Planning Application No: 3/2023/0771

**Proposal: Change of use from booking office to taxi office at first floor level.
Access to first floor reception/sitting area via entrance hall and staircase on
ground floor.**

**Location: First Floor Unit 6A Abbey Works Back King Street Whalley Lancashire
BB7 9SP**

PLAN AS PROPOSED

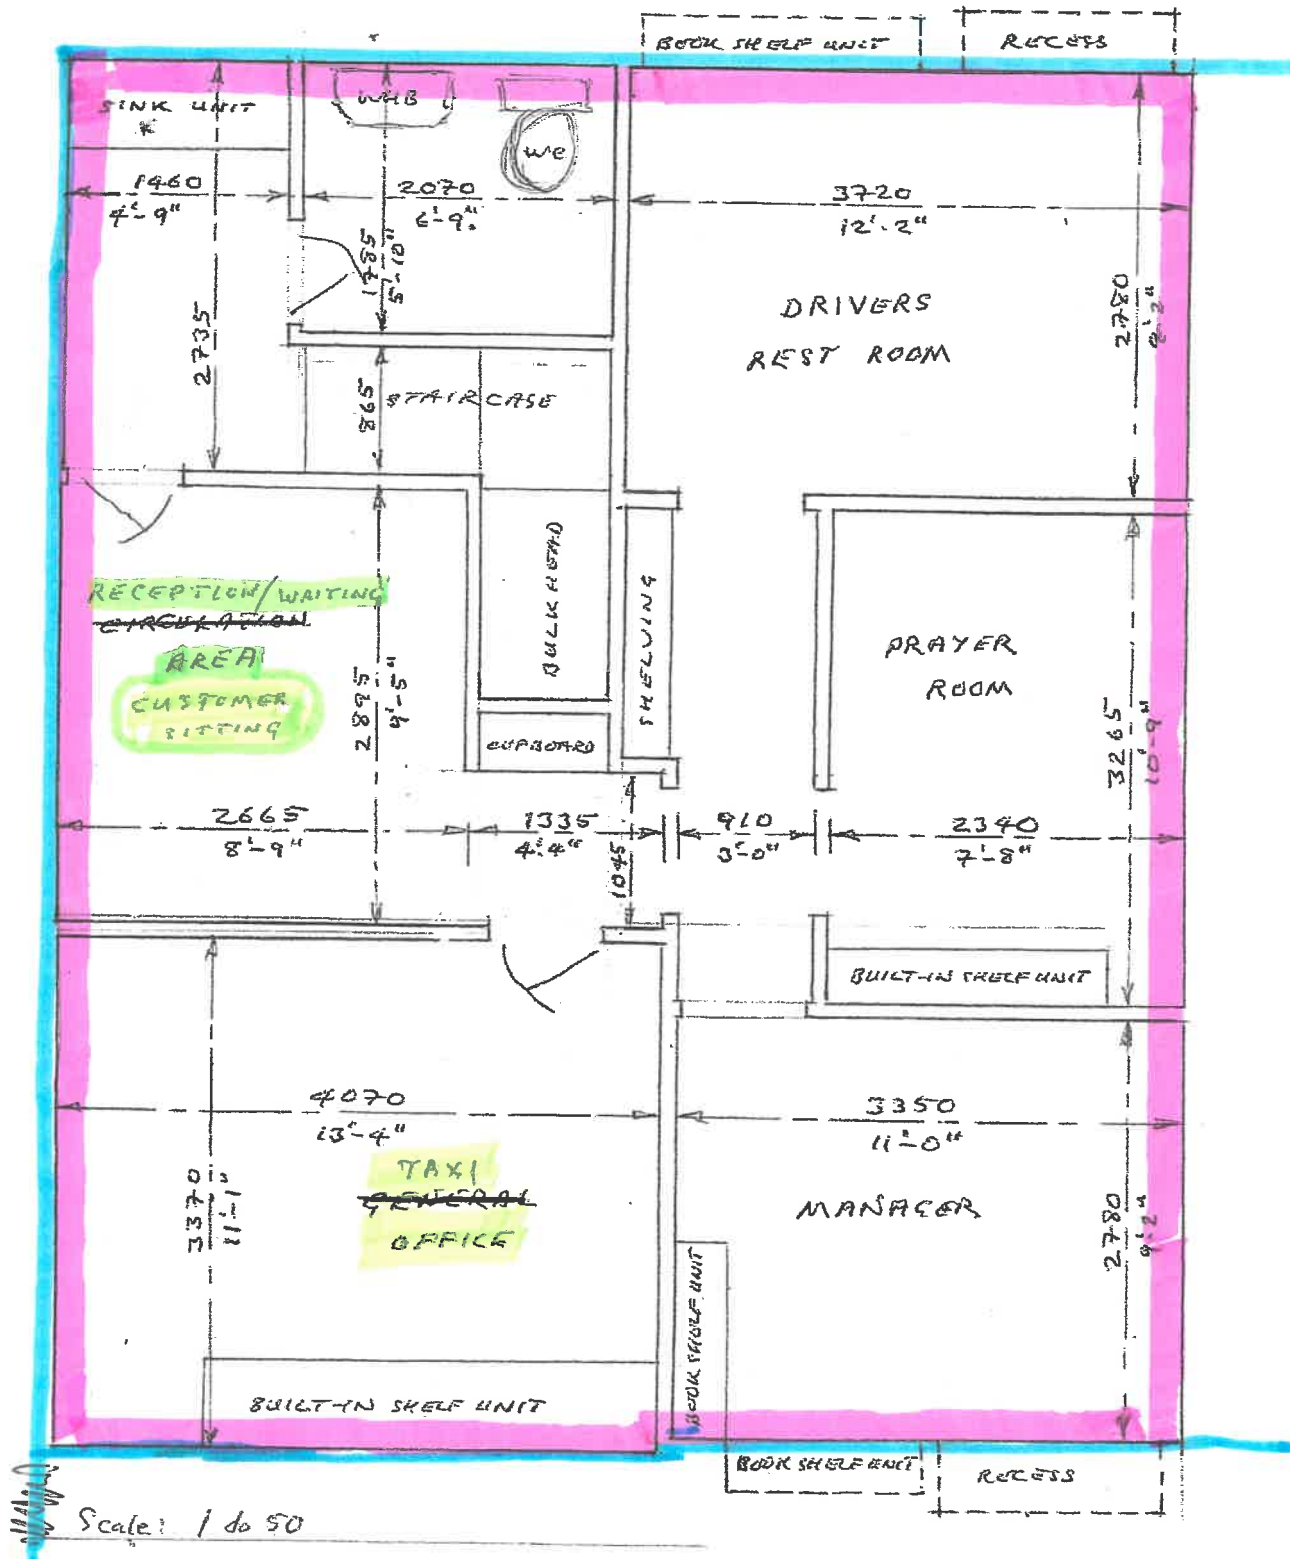
The development of this site will introduce pedestrians (Customer waiting area proposed) into an area where there are no footways and vehicles manoeuvring to a number of locations within a relatively confined area.

We are recommending refusal of this application on highway safety grounds and we are satisfied that the previous highway safety justifications for prohibiting pedestrian access to the site remain relevant and that providing access for pedestrians to the taxi booking office would be detrimental to highway safety.
